Application: SSI 7485

I write regarding the proposed modification to M4-M5 Link, Mod 2 The Crescent overpass and changes to pedestrian infrastructure in North Annandale, Rozelle and Rozelle Bay Foreshore area.

Figure 4-2 Pedestrian and cyclist bridge infrastructure options

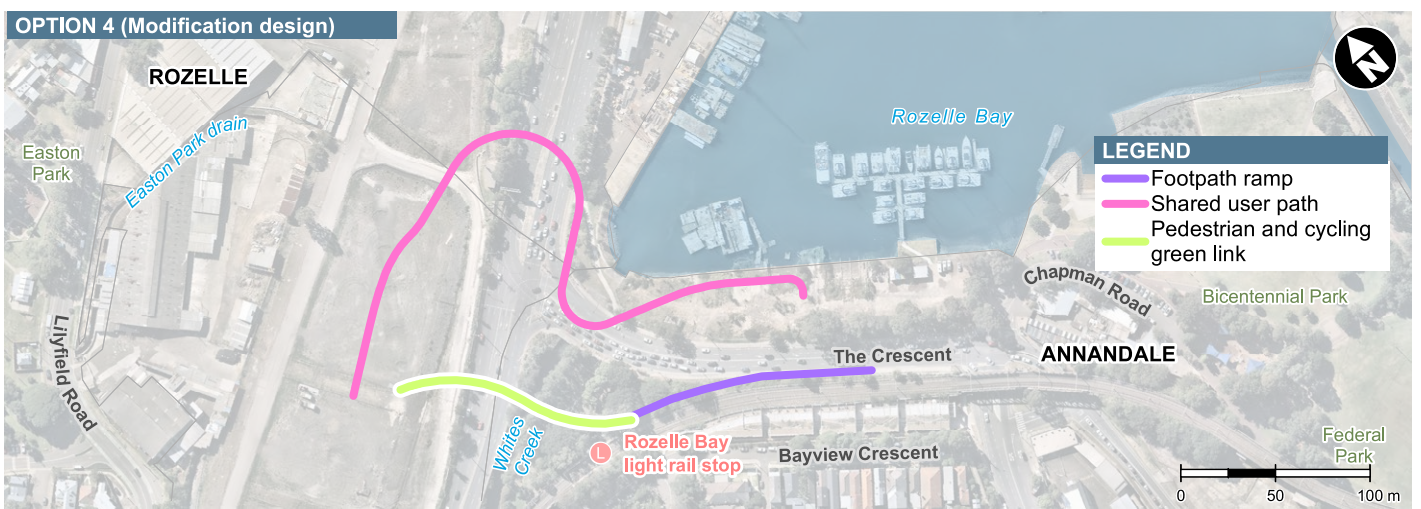
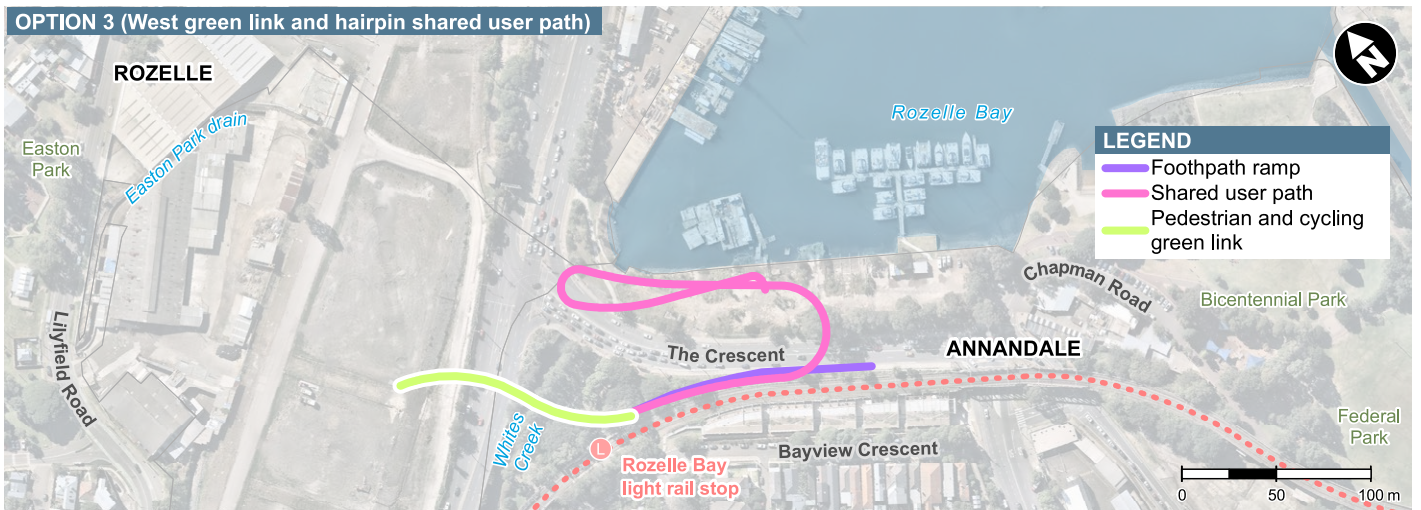
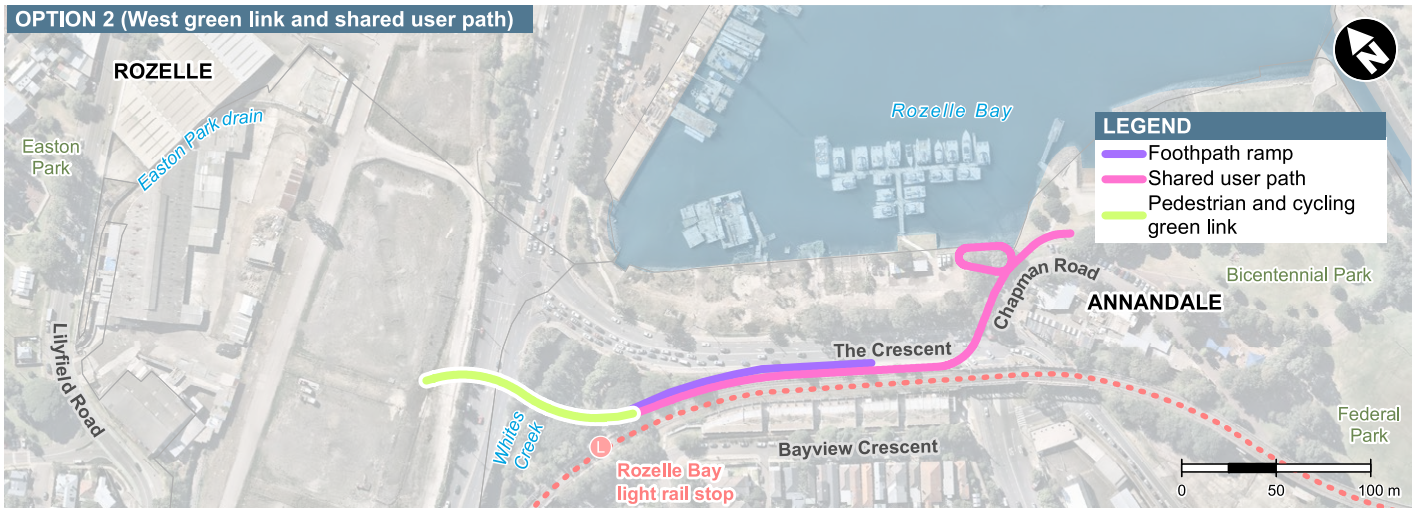
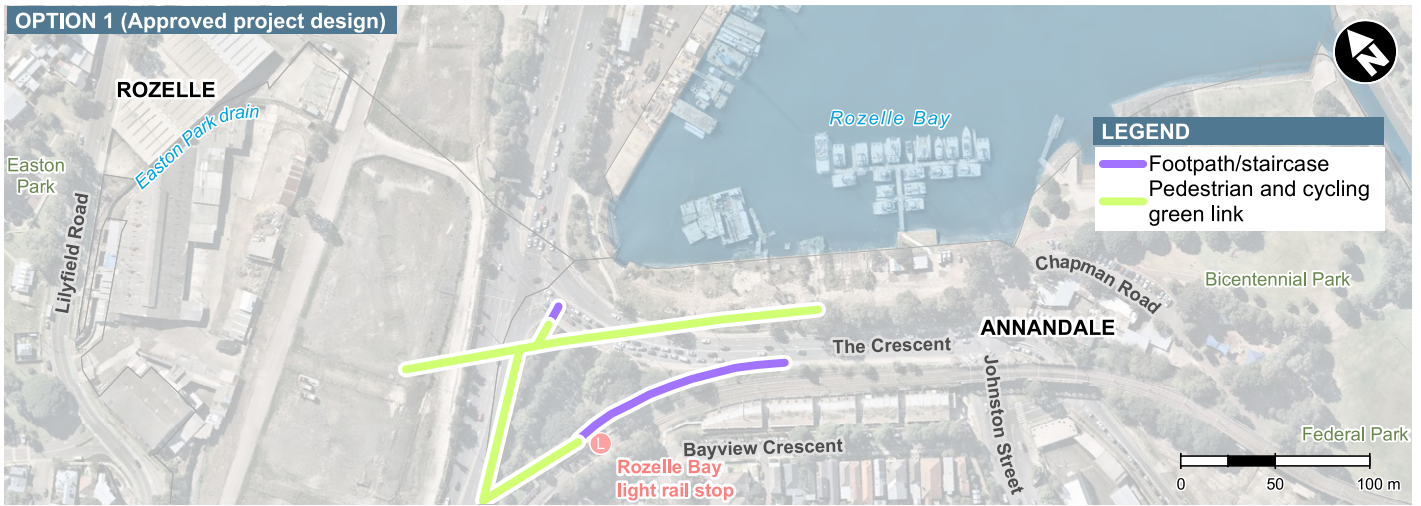
I request RMS work with the community to explore alternate design options to the proposed new car overpass design and the changed pedestrian and cyclist links. I am seeking the reinstatement of the safe, direct access from the approved EIS GreenLink to create a continuous green open space connection from the Rozelle Rail yards and Annandale to the foreshore. The GreenLink was more than just a walkway - it put people central to the design, maximising safety, and providing much needed accessible open space for the community now and into the future Bays Precinct design.

- Removal of direct active links to the foreshore, cutting the community off from the area and the proposed revitalisation of the entire Bays Precinct, including linking the Light Rail and Bus stops to a Ferry wharf and Metro station.

- The significantly reduced safety and increased risk for pedestrians and cyclists with removed access over The Crescent to Bicentennial Park and the increased traffic along Johnson Street.
- Removing the right turn option from Johnston Street to The Crescent will promote rat running through narrow residential neighbourhood streets that are ill-equipped to handle such traffic. There is no good alternative to this connection that doesn't provide unnecessary impact to the local communities of Annandale, Forest Lodge, Glebe, Lilyfield and Rozelle.

- Reinststate the GreenLink connecting communities and green open space from Rozelle to Bicentennial Park
- Relocate and design pedestrian and cyclist connections that are continuous, safe and direct.

Figure 4-4 Elevation: Indicative view of The Crescent overpass

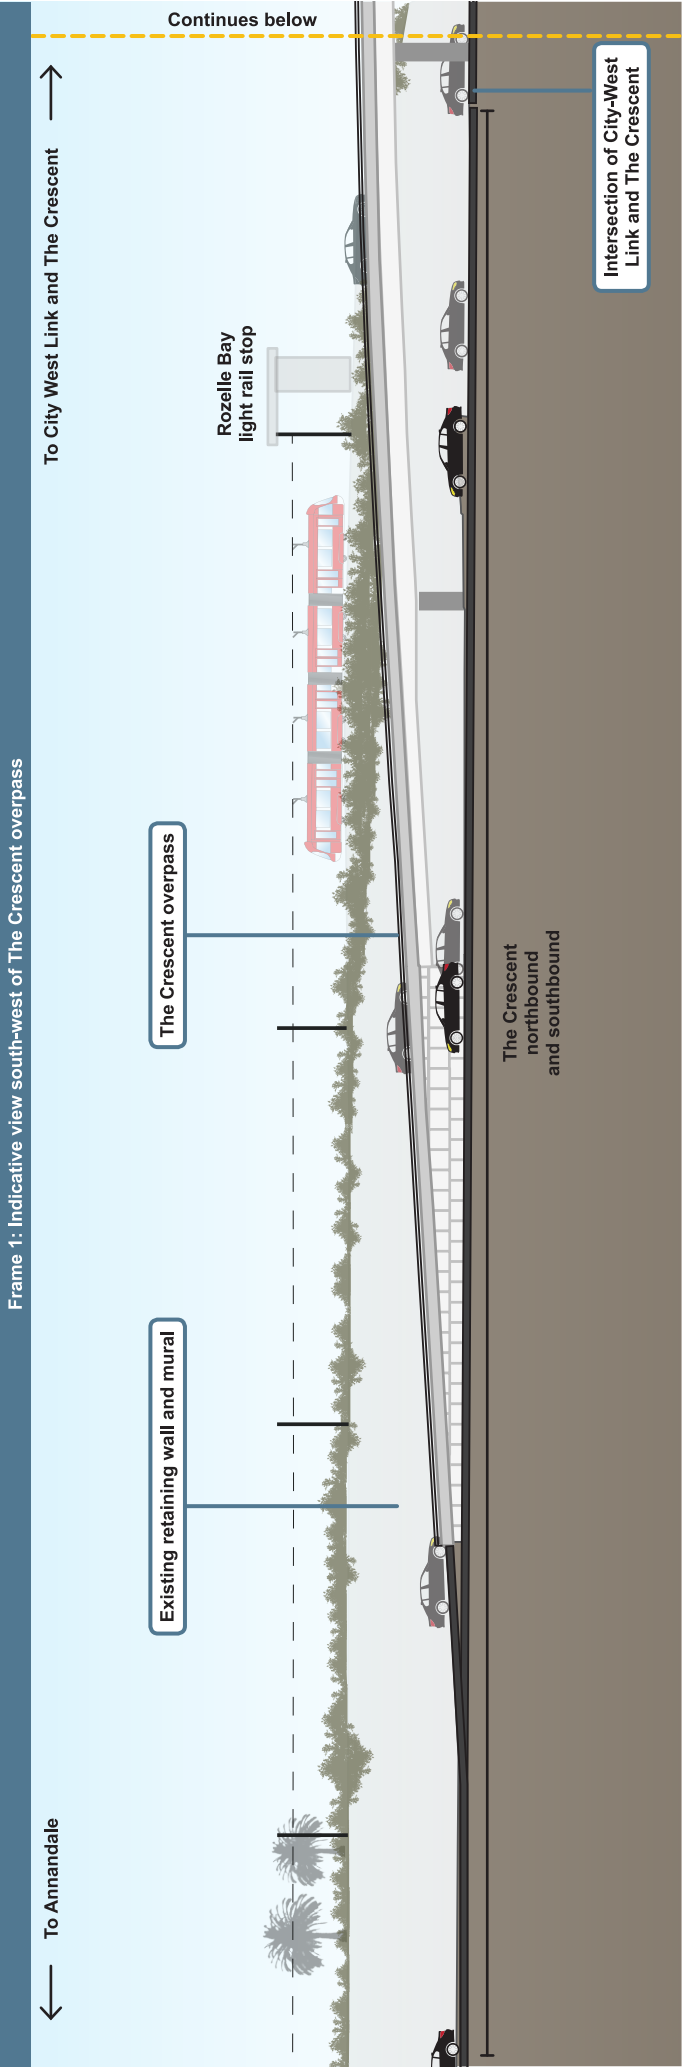
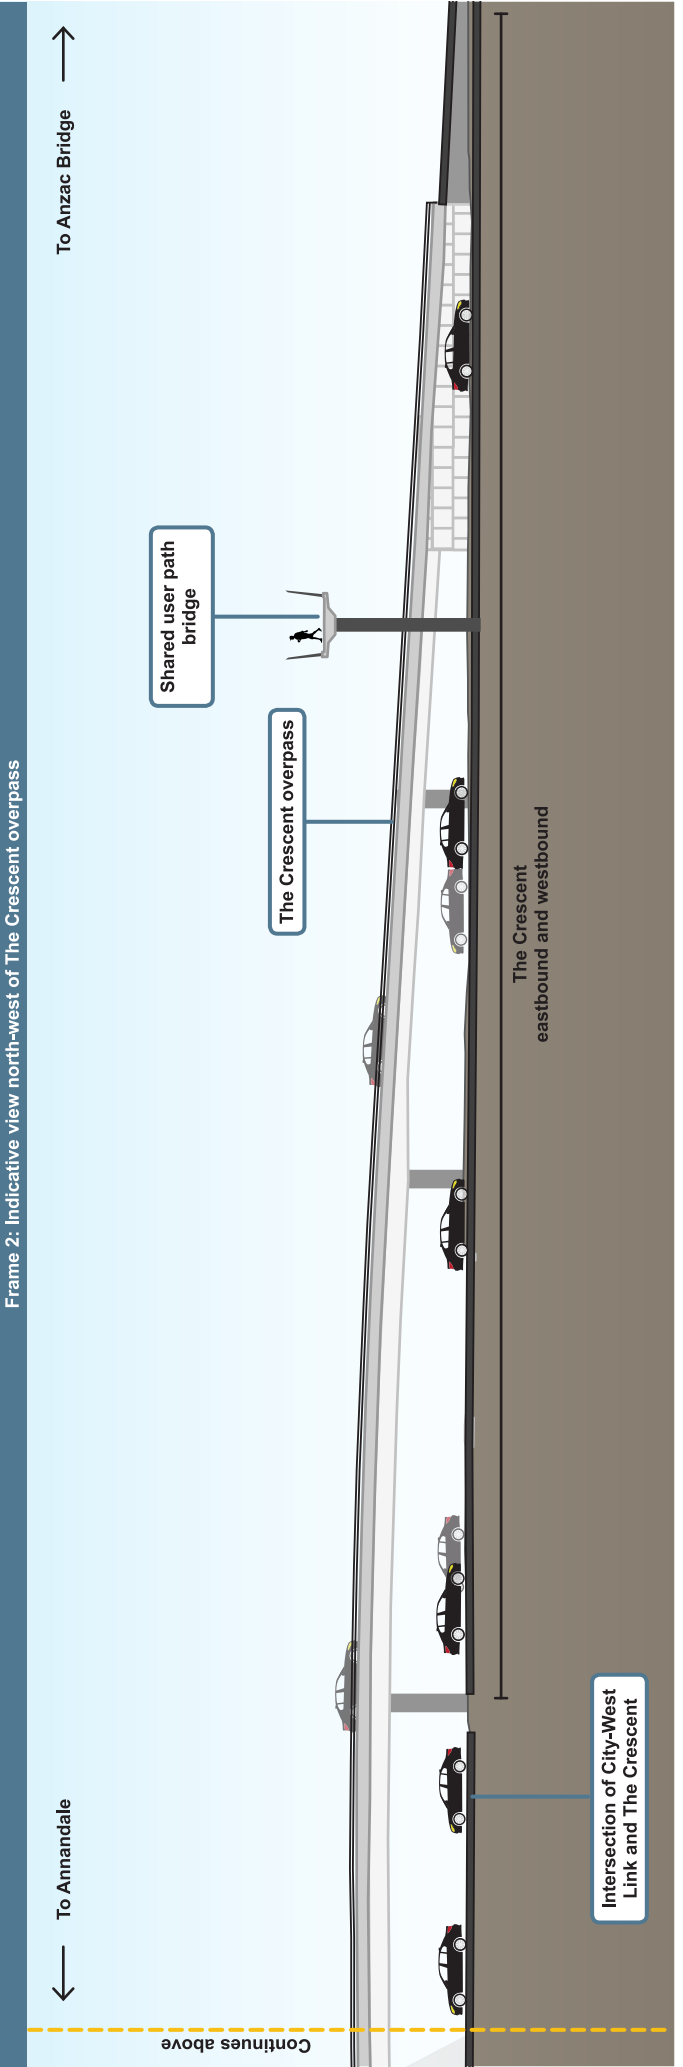
- The inclusion of the vehicle overpass for Northbound traffic on the Crescent, which begs the question of why such a significant increase in surface traffic is anticipated at this location if the Inner West catchment of the Westconnex tunnel network is intended to divert this traffic underground? This proposed modification suggests one of two things:

- Given that neither The Crescent nor Johnston Street are getting wider or increasing in capacity, there isn't a clear justification for inclusion of the overpass (and the attendant impact to the people-focused design elements and the current local community access to local parks and waterfront) other than saving city-bound drivers a minute or so wait at the current traffic lighted intersection at the City West Link.

- The compounded visual impact of a ventilation facility ***AND*** an elevated vehicle overpass, which will significantly impact the district views from Blackwattle Bay and Bicentennial Park in order to save drivers the minor delay of the traffic light intersection at the City West Link. That's a substantial community burden for a very modest traffic benefit.

- **Respond to the local character** Respecting and maintaining the unique heritage, industrial character and topography of the Rozelle Rail Yards through interpretation. **A massive concrete overpass obstructing a historically significant local mural and concrete plaza — really?**

Figure 4-5 The Crescent/Johnston Street/Chapman Road intersection

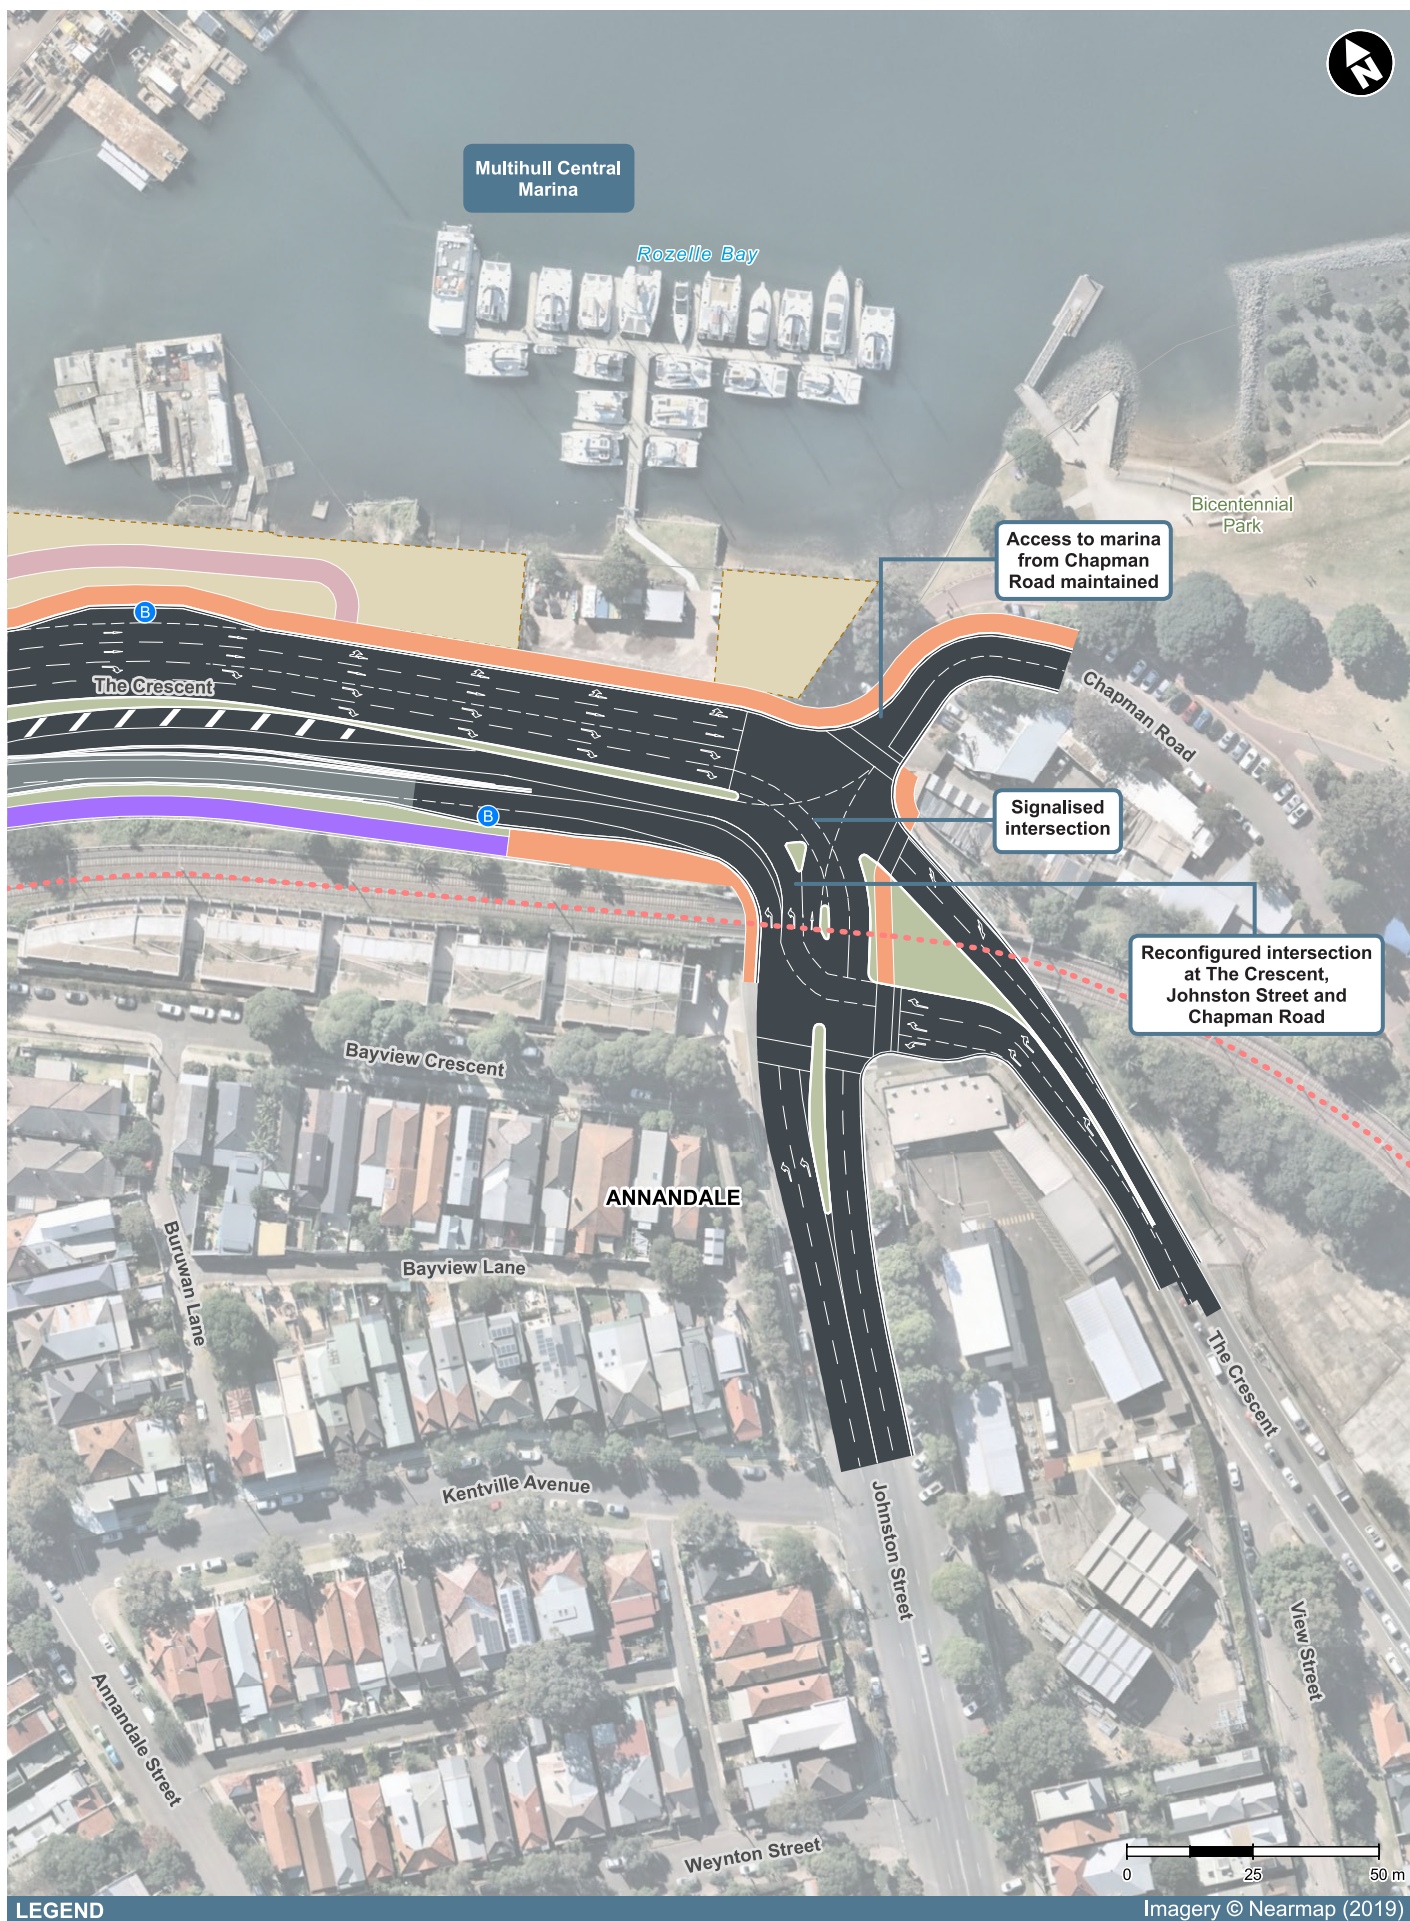
- Being required to cross four sets of pedestrian lights at The Crescent as my option to reach the foreshore from Annandale or from Rozelle Bay light rail stop.
